**REF. OBJECTION TO PLANNING APPLICATION R/221/15/HH
5 HAWKE CLOSE, RUSTINGTON BN16 2AT, WEST SUSSEX**

With regard to planning application R/221/15/HH, I wish to raise an objection especially to the proposed rear upper level extension.

FIRST FLOOR PLAN 1:50 @ A3

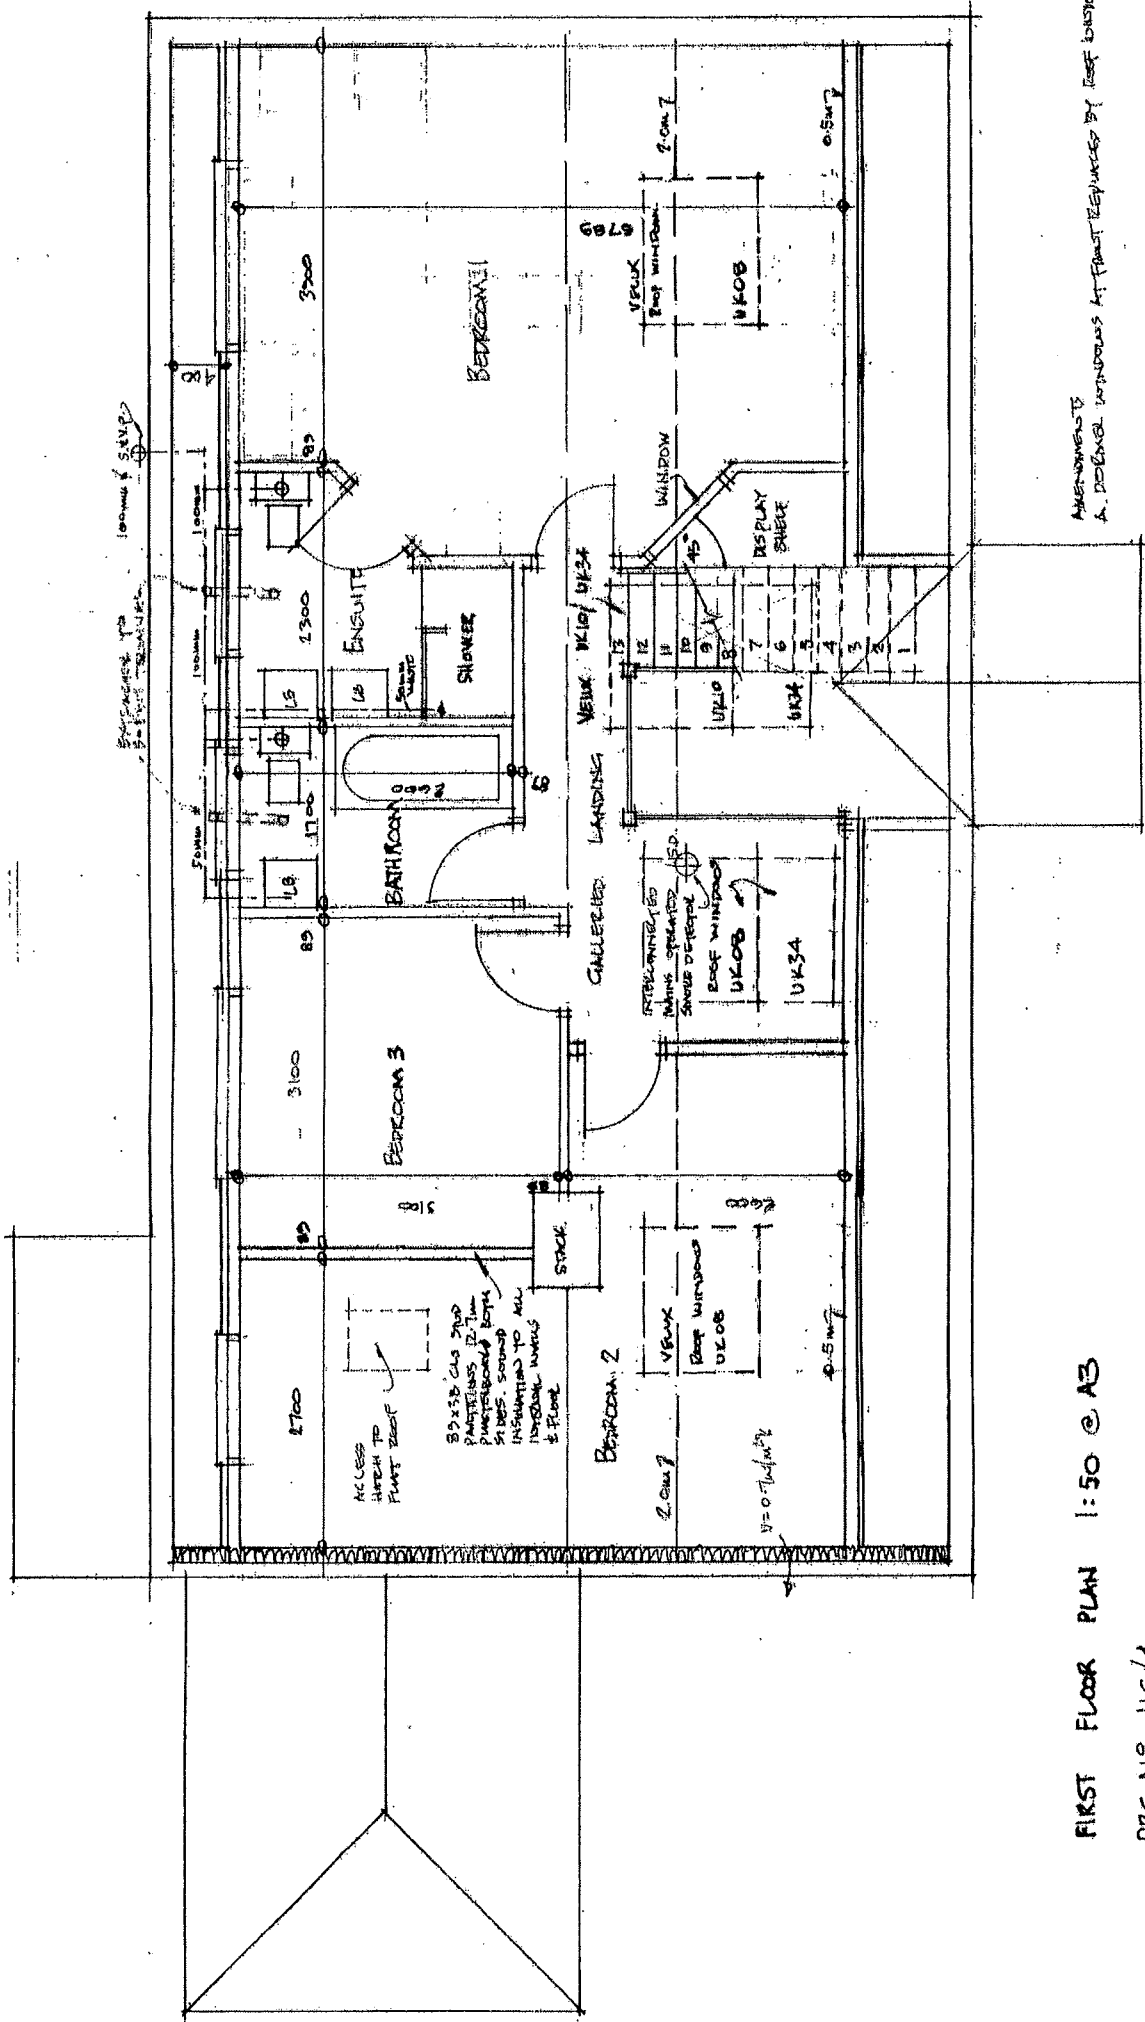
I live next door to 5 Hawke Close at number 4 Hawke Close. The proposed first floor flat roofed extension along the whole length of the bungalow at the rear including five windows, will clearly be intrusive and visible in profile from my back garden and study.

The proposed changes are a material change to the profile of the roof and will dominate and detrimentally impact the view from my back garden and study. The proposed design could also have a negative material effect on my property.
